DECISION DELEGATED TO HEAD OF PLANNING

Application No: H08-0346-21 **Applicant:** IMN Properties Ltd.
Proposal: Proposed pair of semi detached dwellings
Location: Adj. 21 Salem Street Gosberton Spalding
Terminal Date: 1st April 2022

CASE OFFICER ASSESSMENT

Front Elevation
Scale: 1:100

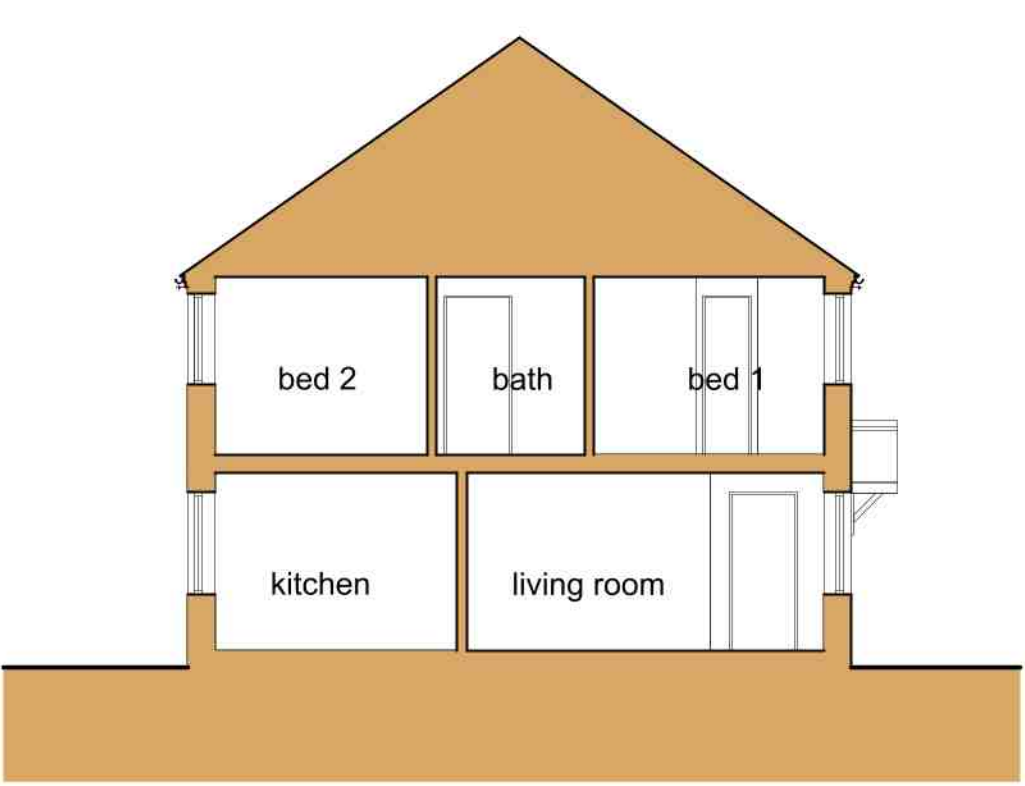
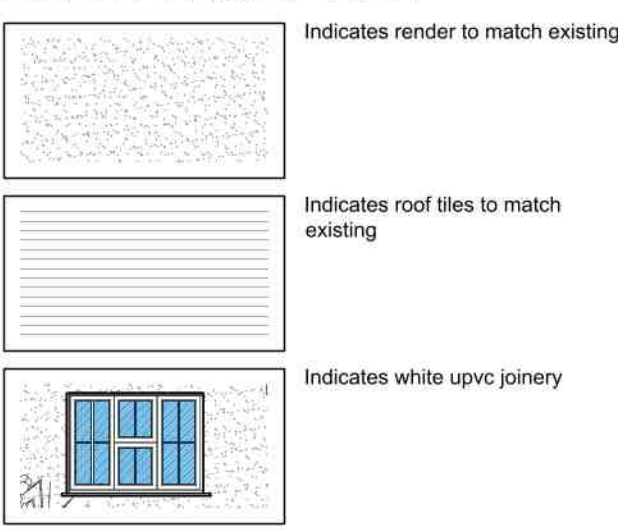
There are 2 windows proposed which could be considered to present an overlooking risk. Those being the 1st floor west-facing bathroom window of the southern property and the north-facing side elevation window on the northern property. Both of these windows create views from non-habitable rooms (a bathroom and a hallway) and so it is unlikely that overlooking would be an issue. In the case of the north-facing window, this vantage point only looks directly onto the rear car park of the High Street Co-Op shop, and so visibility into the rear residential garden of 50 High Street would only be possible over a substantial distance, covering an open, publicly accessible plot. The closest point of Number 50 High St's boundary is approx. 10.7m away, with the closest elevation of that dwelling being a further approx. 4.4m, away, at 15.1m. Furthermore, the west-facing window which is assessed as a potential source of overlooking is screened from the rear garden of the property to the west by a large wall which would limit some overlooking risk - moreover, due to the viewing angle of the proposed window, the only potentially visible section of the property would be the very end of the rear garden.

It is plausible to suggest that the 1st floor bedroom window on the northern gable elevation of 21-23 Salem St could overlook the proposed houses, specifically into the upstairs southern gable elevation window. This is particularly the case as the window which could overlook into the proposed houses is a habitable room and the separation distance is only at an approximate 5m. However, both of the potentially overlooked windows on the proposed development form part of non-habitable rooms (landing and a downstairs bathroom), the latter of which will consist of opaque glass, ensured by means of condition. Therefore, the risk of loss of privacy is in this instance deemed to be negligible.

Site Site
Scale: 1:200

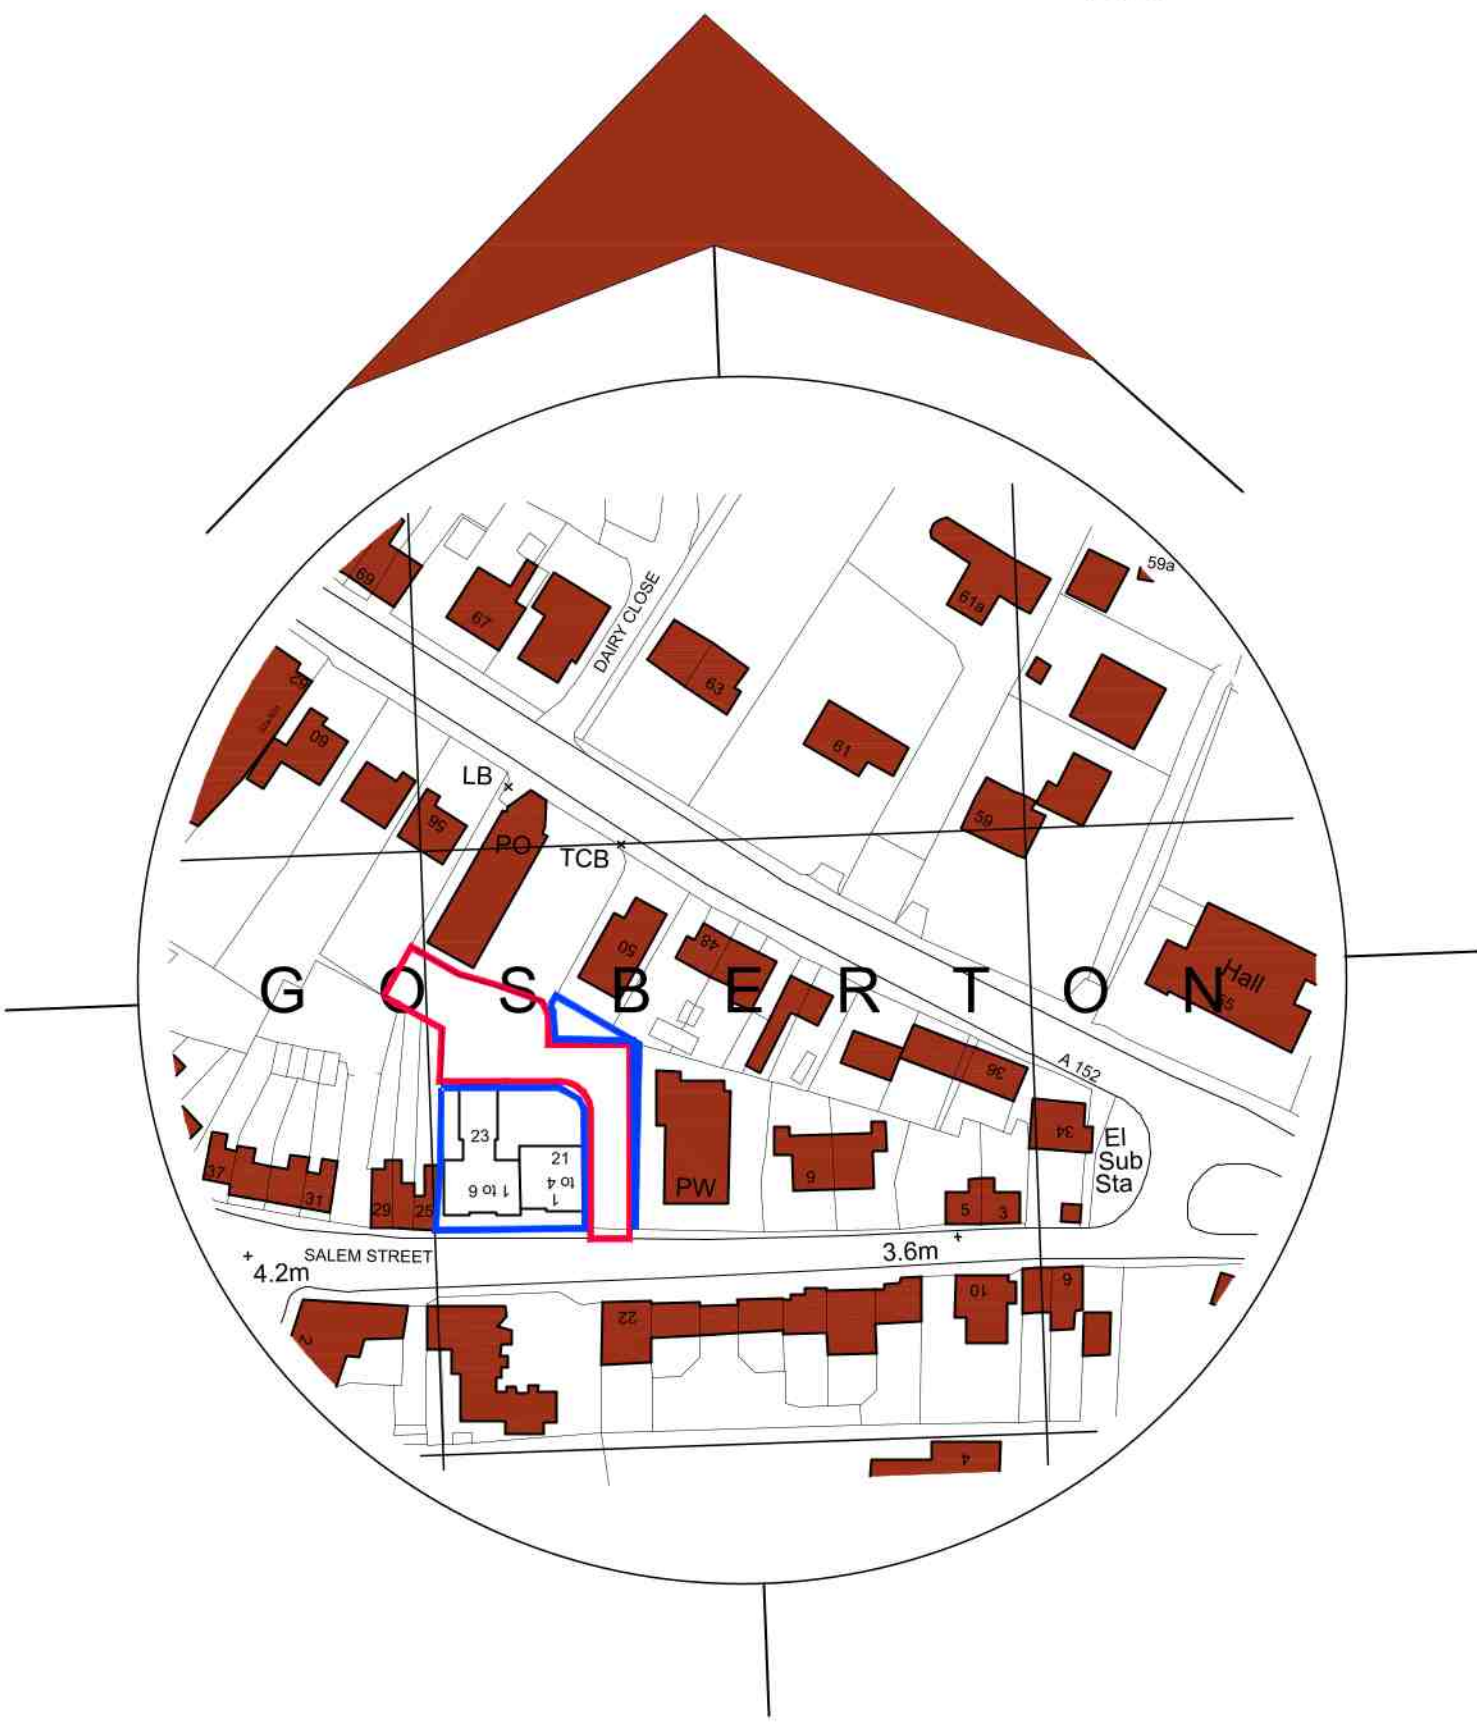
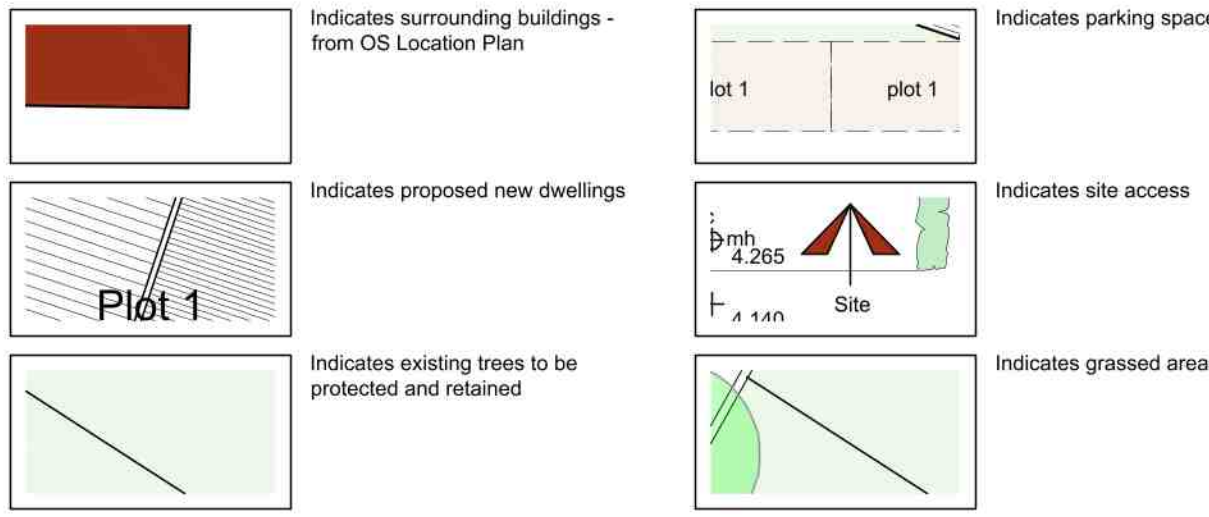
The block of 2 dwellings is proposed to be approx. 1.5m from the western boundary, approx. 20.4m away from the eastern boundary, approx. 1.5m from the northern Boundary, and separated from the rear elevation of 21 Salem St by approx. 2.9m. These are acceptable separation distances and will allow suitable access to the rear. The proposed pair of dwellings would be approx. 11.465m in width by 8.765m in depth. The driveway would be situated to the front of the dwellings, sharing the extant vehicular access for 21 Salem St and is suitable for manoeuvrability.

Whilst many of the received objections were based upon the impact upon road safety and parking along Salem St, the local highways authority have been consulted and found that due to the fact that the access and parking arrangements for the site remain unchanged, save for the creation of 4 new parking spaces within the existing plot would not have an undue effect upon road safety. Furthermore, they found that the created parking spaces were sufficient to fulfil the needs of the development - this is in accordance with Policy 36 and Appendix 6 of the South East Lincolnshire Local Plan, as the provision of 2 spaces per property falls within the essential minimum standard for 3-bedroom properties.

Documentation later received confirmed the allocation of spaces for the remainder of the Salem St site, confirming that the site was capable of receiving 2 parking spaces for each of the existing 2 bed flats, 1 parking space for each existing 1 bed flat and 2 guest spaces in addition to the provision for the proposed properties. This is acceptable under Policy 36 and Appendix 6 of the South East Lincolnshire Local Plan (2019).
